Uniting Kingscliff Redevelopment

SSD 47105958

From Colin Lidiard

Please register this submission as an **objection** to the Uniting Kingscliff Redevelopment SSD 47105958.

BUILDING A

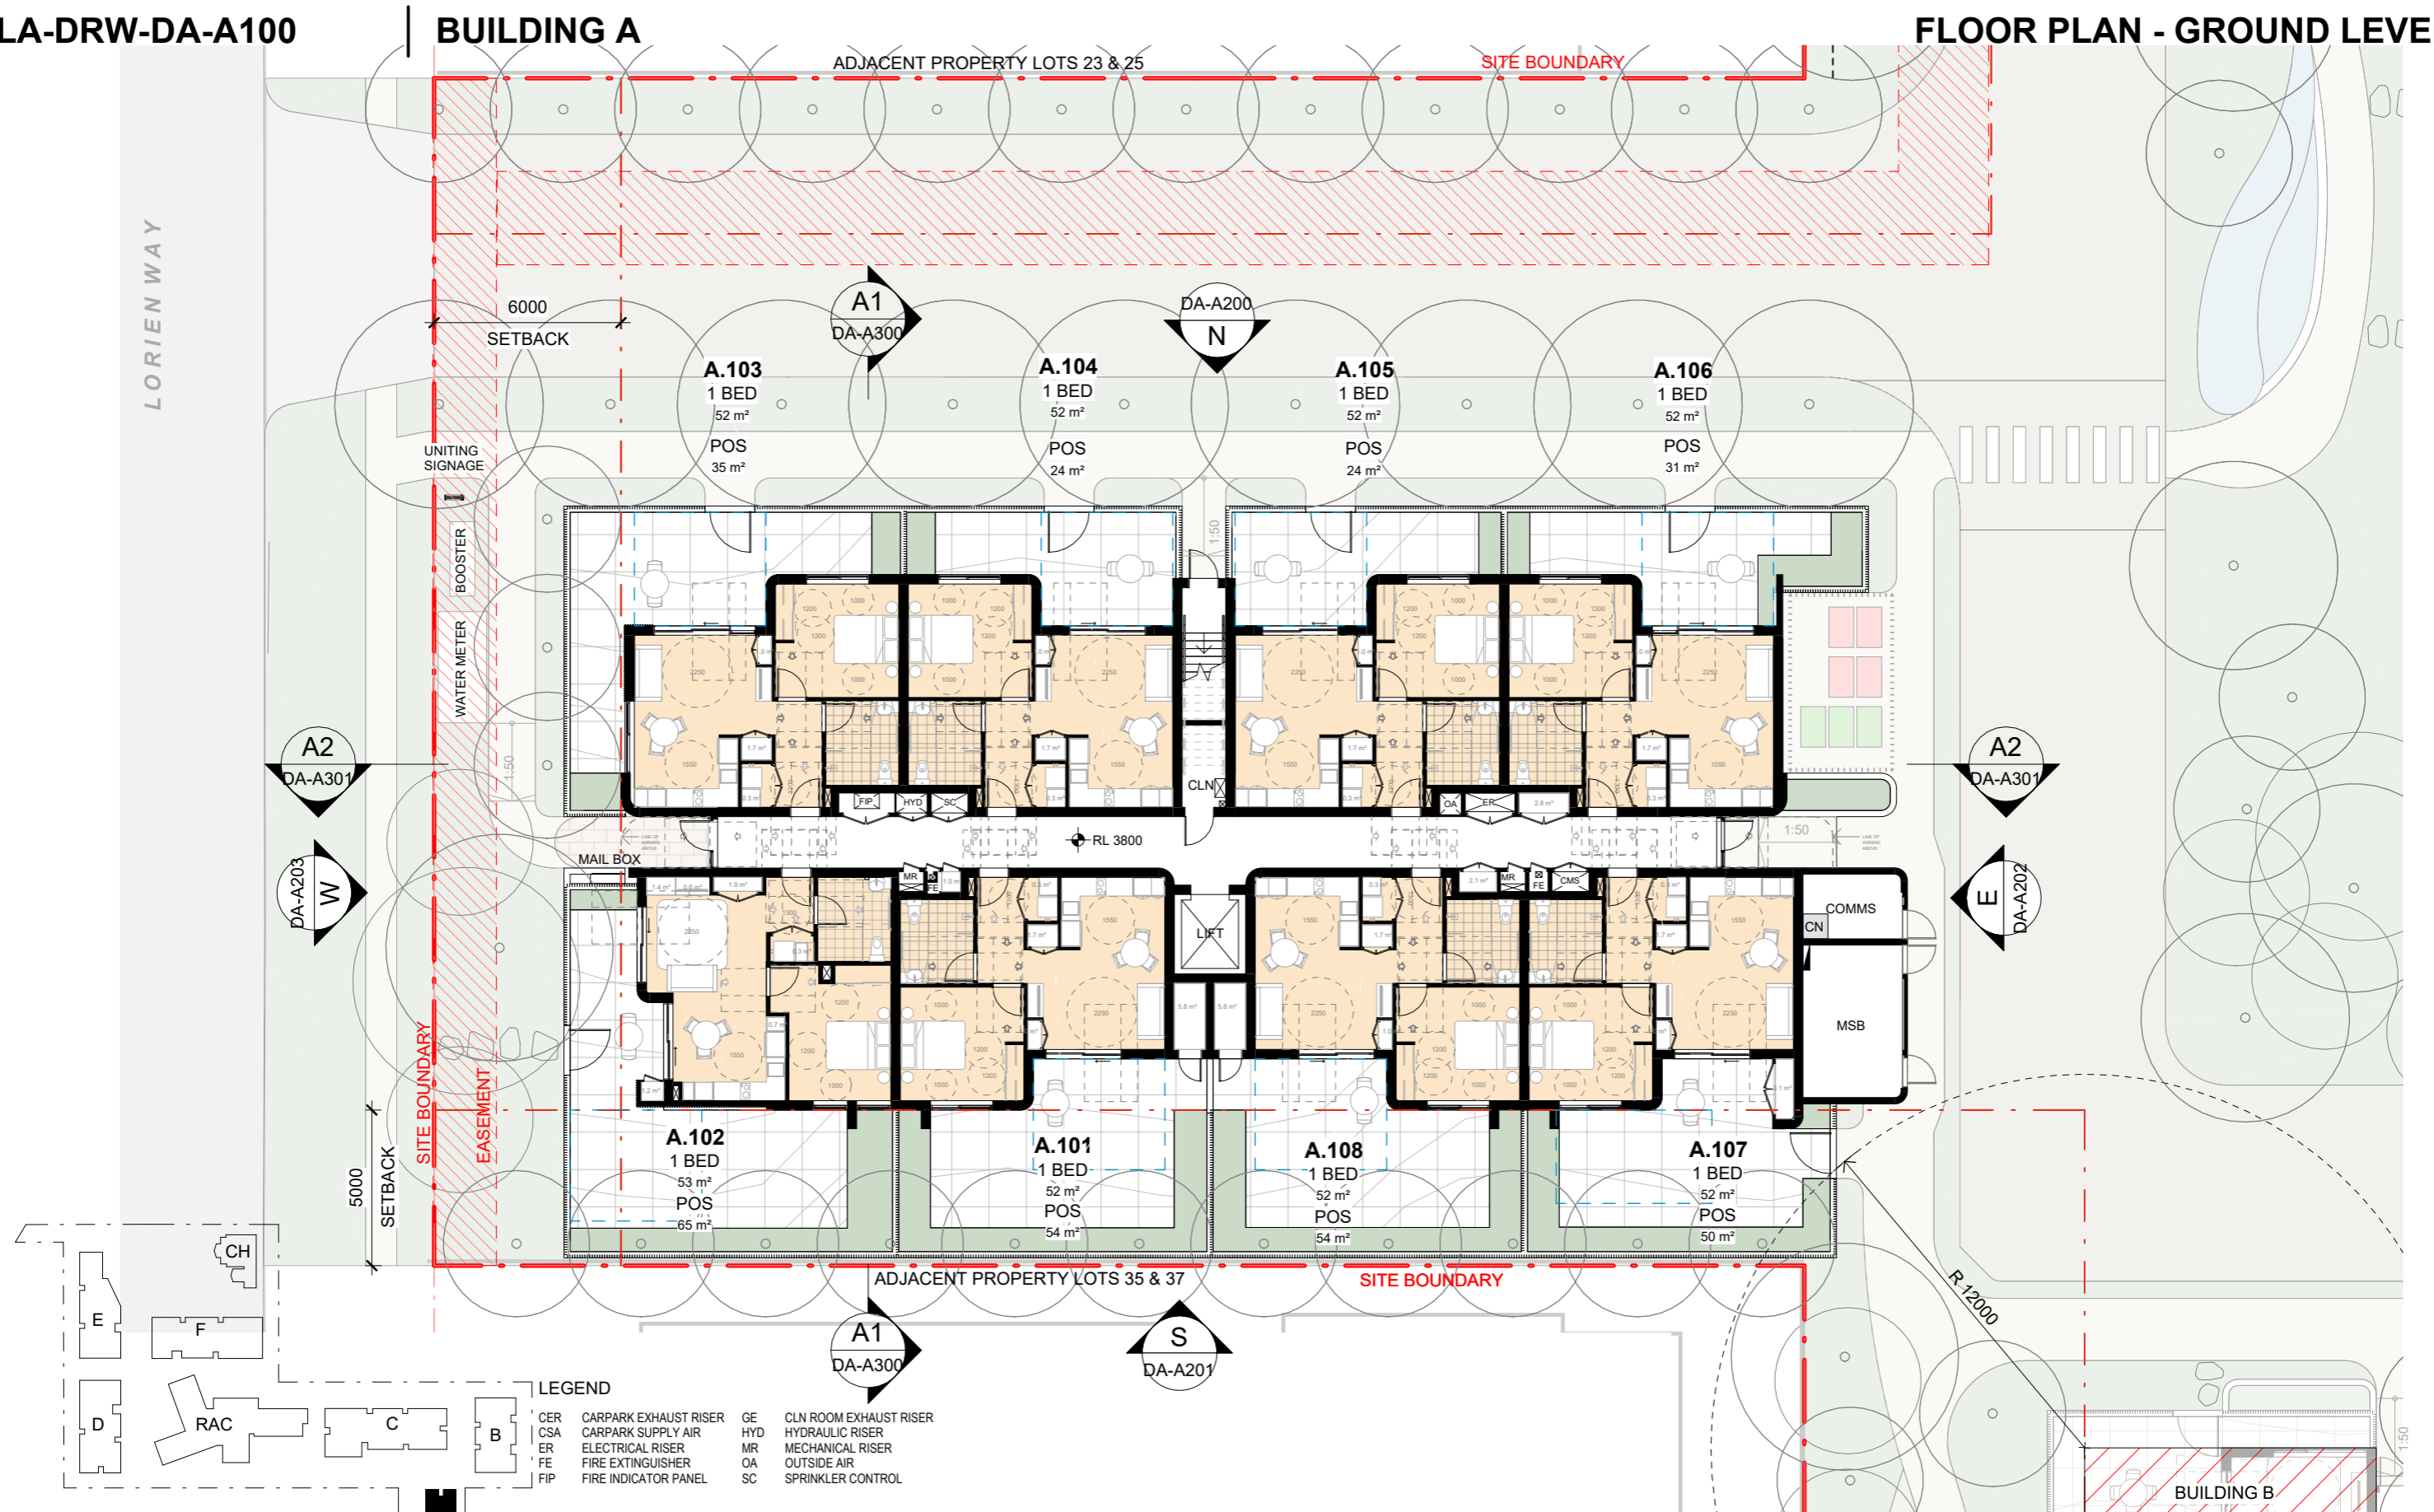
Objection: Given that EIS states that Building A requires a variation to the setback, UK proposes a **5m** setback, the ADG (page 47) states " for apartment buildings up to 4 storeys there should be a minimum 12m setback between habitable rooms/ balconies." My living rooms face the balconies and courtyards of the south facing apartments of Building A and vice versa. The ADG also states that " at the boundary between a change in zone from apartment buildings to lower density area increase the building setback by 3m."

Despite telling the SDRP three times that Building A had been reduced to a **single loaded corridor** all the plan diagrams show that building A is in fact a **double loaded corridor** with balconies directly overlooking my living areas (dining, kitchen & living room). In addition, the building is set back only 5 metres despite the claim on page 68 of the EIS that the development achieves a minimum 9m setback. It seems to me that UK wants to build a prohibited "residential flat building " on R2 zoned land, probably on the assumption they will get the land rezoned, if they manage to consolidate the 5 land titles. But, at the the same time, want to capitalise on the the R2 zone's 5m setback, when in fact the Apartment Design Guide requires apartment buildings up to 4 storeys to have a 12m setback between habitable rooms, with a further 3m increase to the building setback from the boundary when there is a change in zone from apartment buildings to a lower density area both of which would be applicable under this current proposal.

This picture shows the view from dining room looking North; proposal puts a double loaded corridor two story block of units (only half of which can be seen in figure 3-2 above) where the nearest wall is i.e. 5m from fence line. With habitable rooms from both dwellings facing each other. The photo taken from the EIS disingenuously only shows half the building but we will have the habitable rooms from the UK development facing directly in to our living, kitchen and dining rooms.
